476 Stevens Ave

Subject: 476 Stevens Ave

Good afternoon, I am reviewing the proposed renovation at [476 Stevens Avenue](#) and have a few questions:

**A10.1**

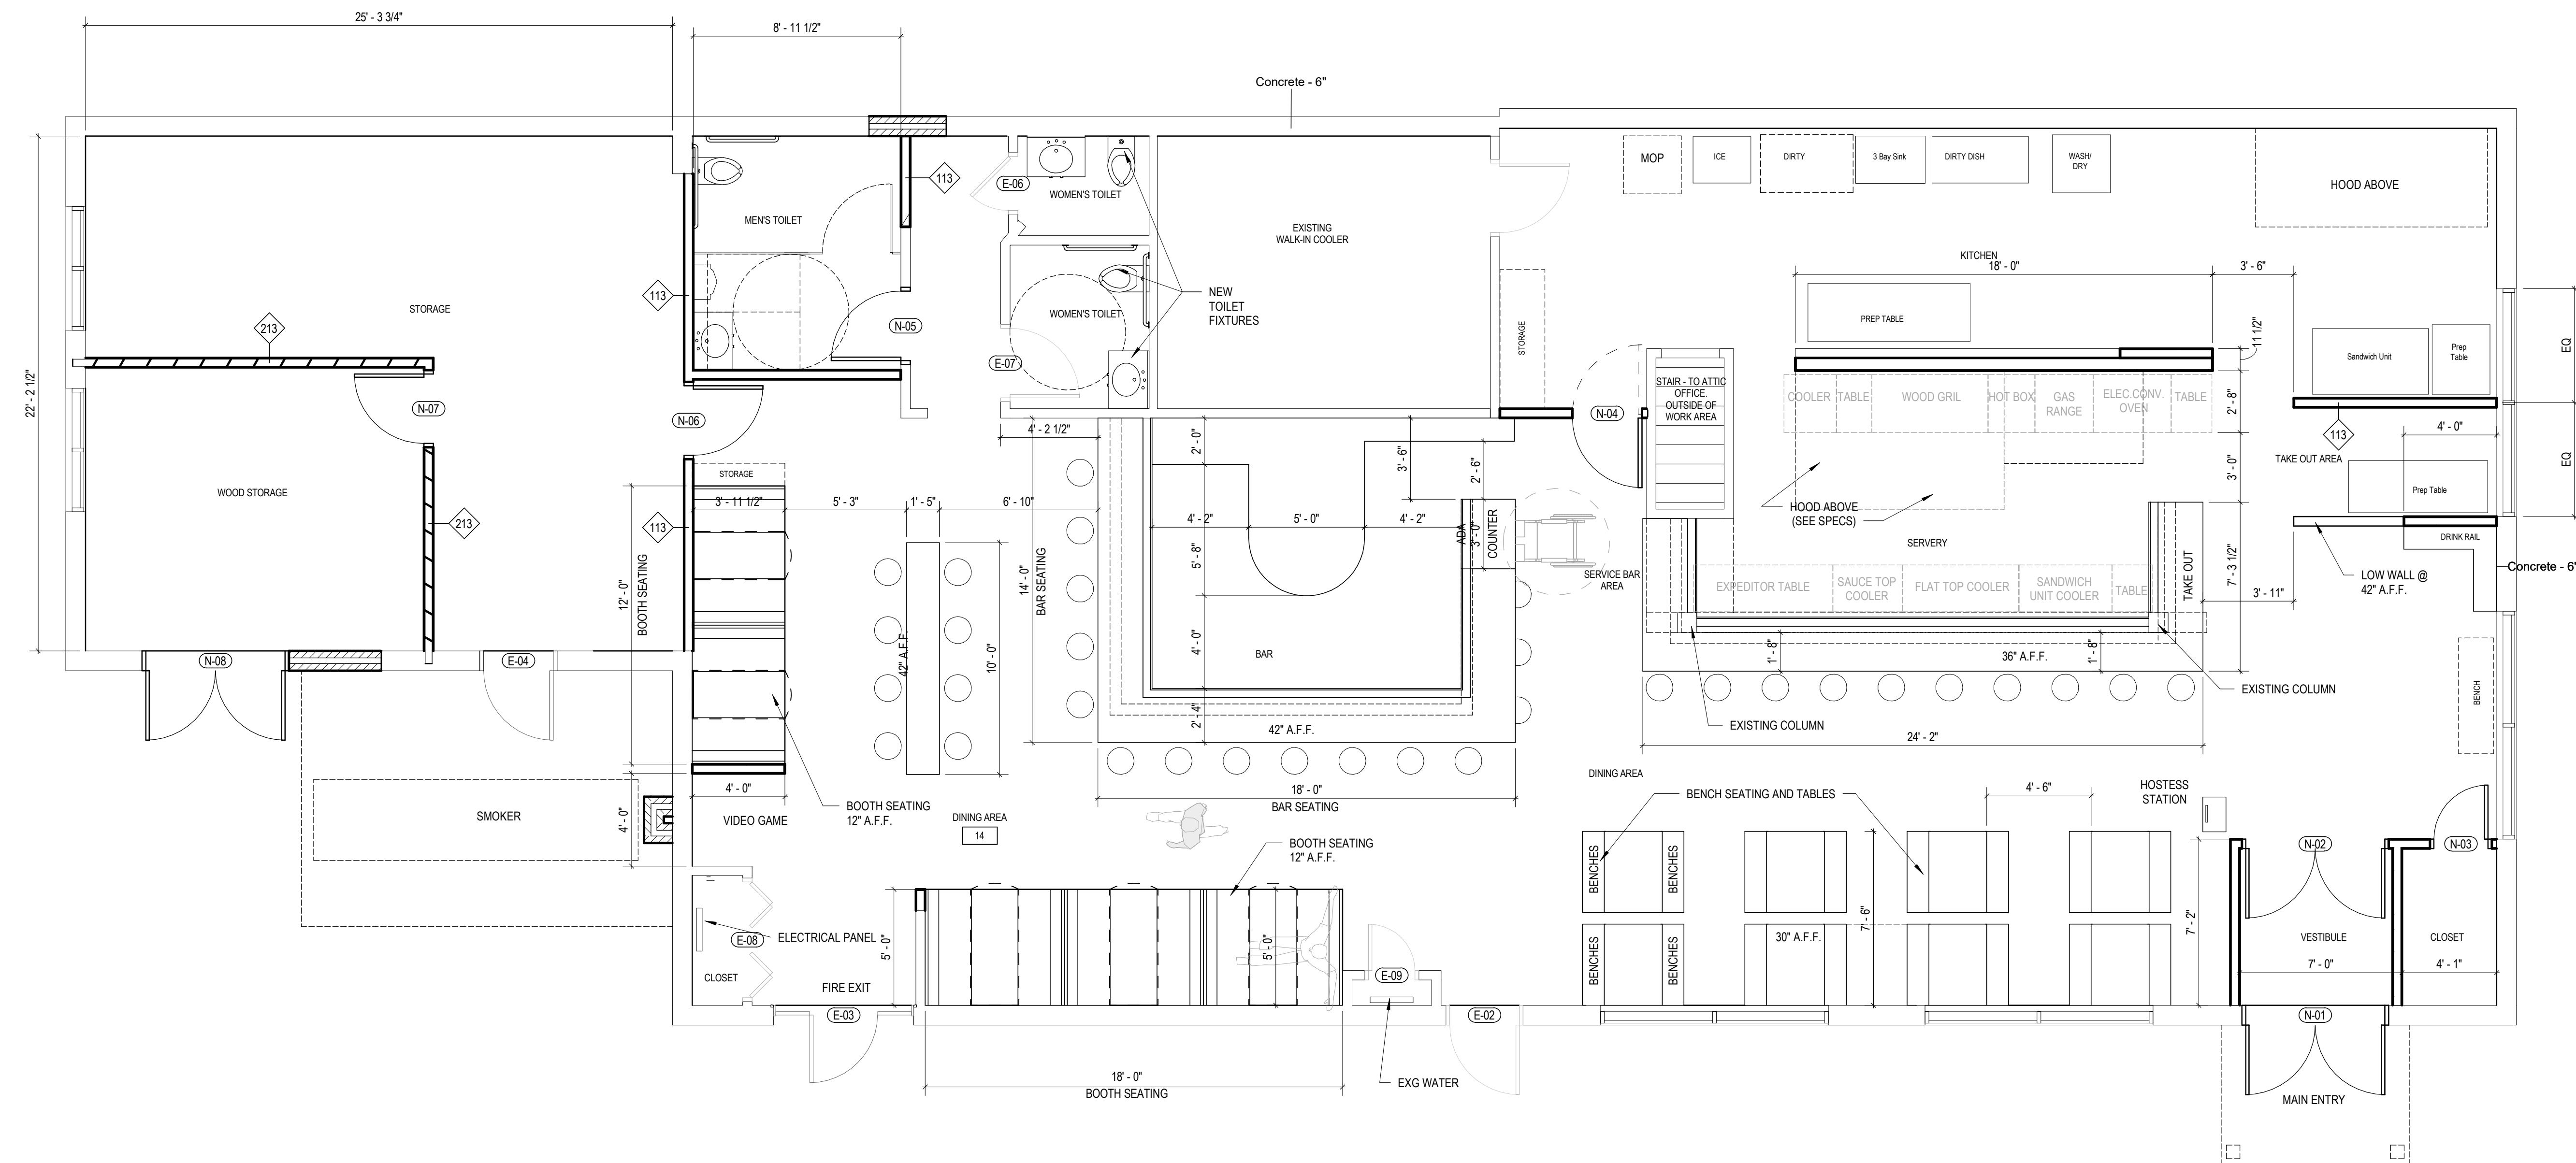
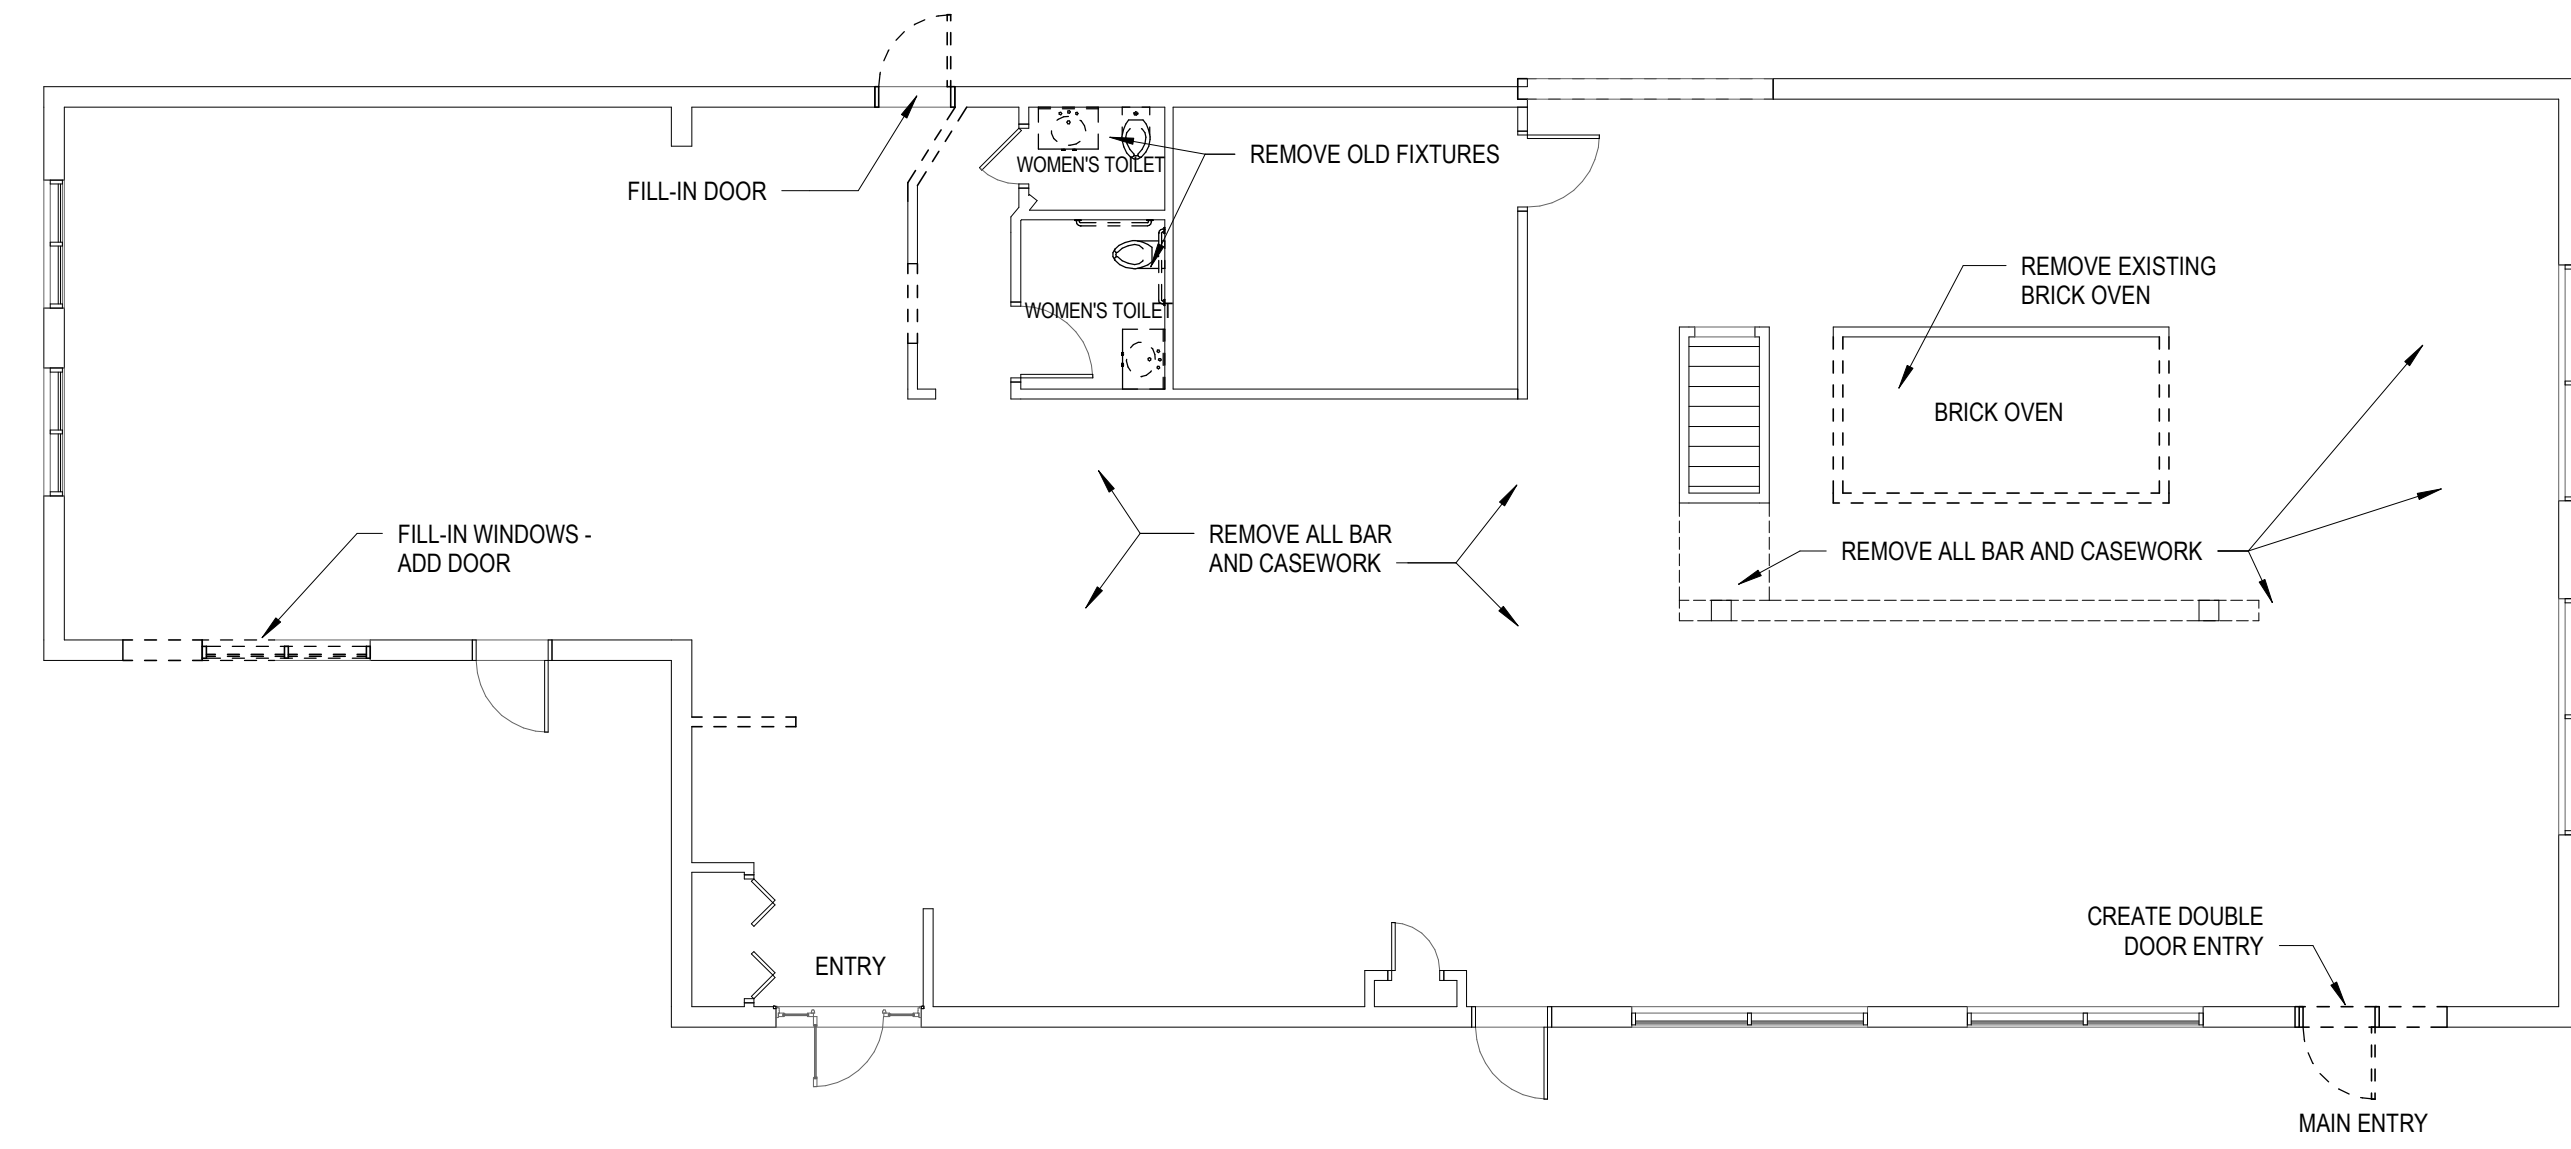
4. What is the exterior smoker and is that a proposed new chimney shown on A10.1? It is not a new chimney, it is existing. The smoker is an A.N Bewley model 1100 pit BBQ system.

14'-0" L x 36" deep with right hand firebox. 18" diameter stack strapped to existing chimney.
